# CITY OF ALBUQUERQUE

**Re: Ichiban Remodel**  
**10701 Corrales Rd NW, 87114**  
**60-Day Temporary Certificate of Occupancy**  
**Transportation Development Final Inspection**  
Engineer's/Architect's Stamp dated 5-1-20 (AA) (A14D017)  
Certification dated 8-24-20

AA.1

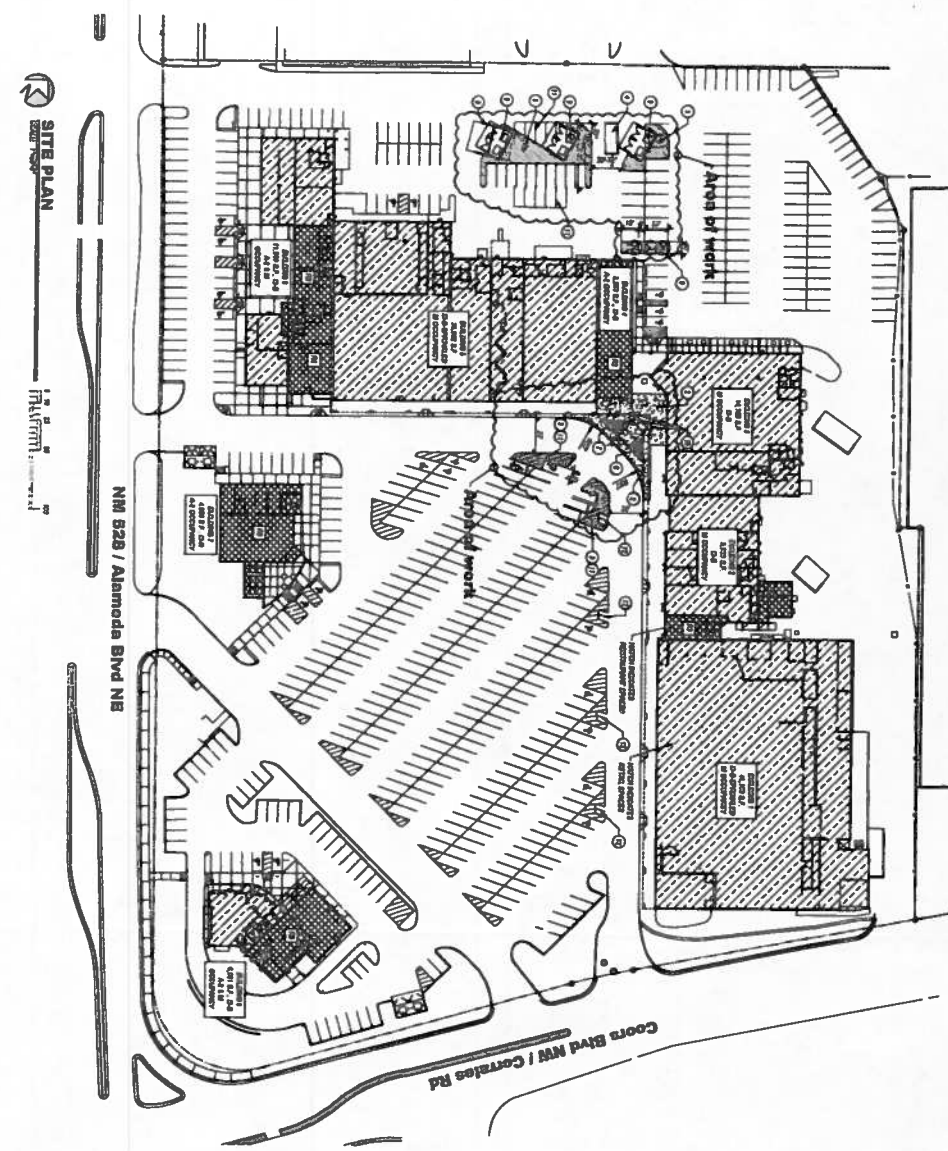
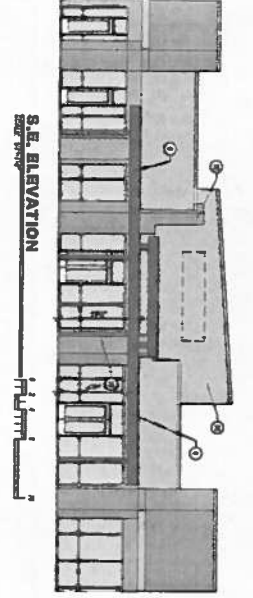
- Please restriping parking.
- Please add Trash Container

Please update ADA signs. The ADA accessible parking sign must have the required language per 66-7-352.4C NMSA 1978 **"Violators Are Subject to a Fine and/or Towing."**
